From: Lewis, Trevor <Trevor.Lewis@lancashire.gov.uk>
Sent: 23 May 2014 17:20
To: Claire Booth
Cc: planning; ENV LHS Customer Service; John Macholc; Coombe, Andrew
Subject: planning application 3/2014/0310 The Old Workshop, Grindleton Brow, Grindleton

From: Jane Tucker [mailto:Jane.Tucker@ribblevalley.gov.uk]
Sent: 28 April 2014 16:16
Subject: Consultation on planning application 3/2014/0310 The Old Workshop, Grindleton Brow, Grindleton

Please can Claire Booth have your comments on the above planning application? It is for the renovation/conversion of former two-storey workshop and lean-to outbuilding, to create family dwelling comprising living room, kitchen

Proposed Site Plan

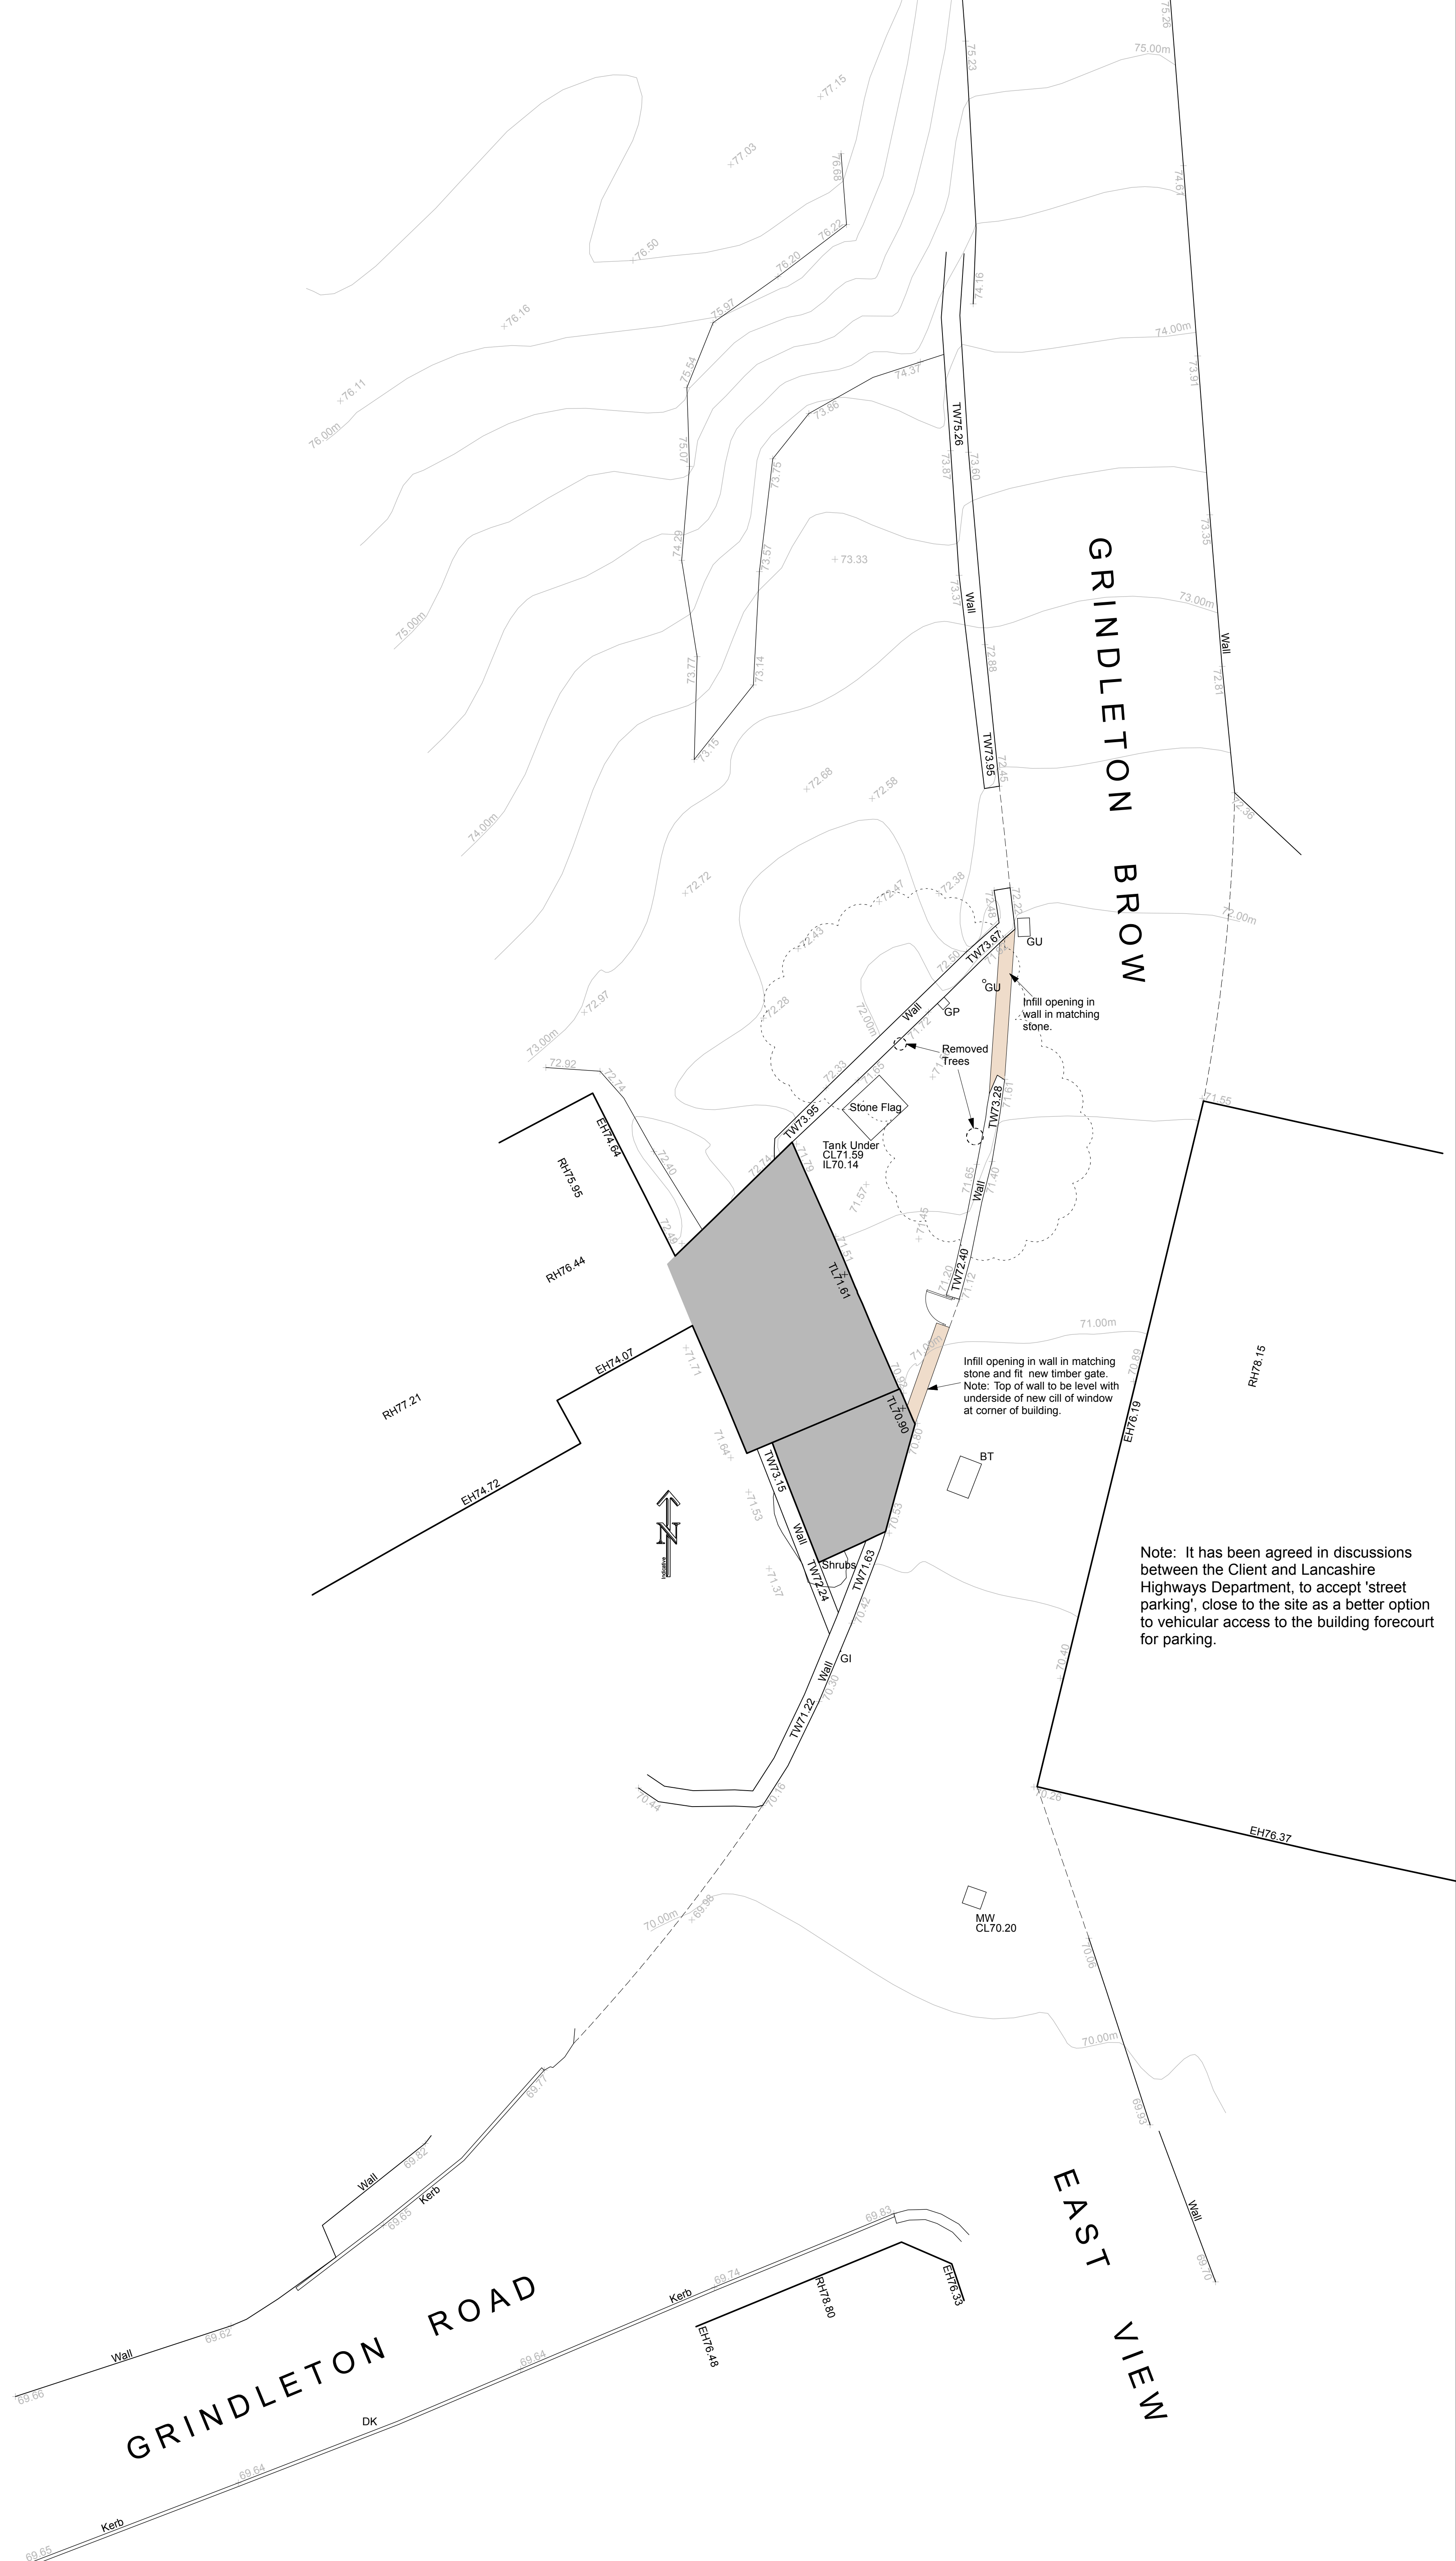
On the "Proposed site plan" the developer states that it was agreed in discussions between the Client and Lancashire Highways Department to accept 'street parking' close to the site as a better option to vehicular access to the building forecourt for parking". I confirm that this is the case. However I regret that after further consideration and discussions with colleagues and my team leader, I have had to review my opinion. The nature of the highway here, and the tendency that visitors, delivery vehicles and the residents themselves will park in the highway close to this dwelling, will create an unacceptable hazard in the highway. There is a possibility to park along Ribble Lane, but there is no guarantee that future residents will always park there, and there is no way to enforce parking along this road for residents and visitors.

I have already ruled out the possibility of parking a vehicle within the site because of the lack of visibility along Grindleton Brow and the subsequent hazards of driving in and out of the property.

As a result of these considerations I would have an objection to this proposed development on grounds of highway safety.
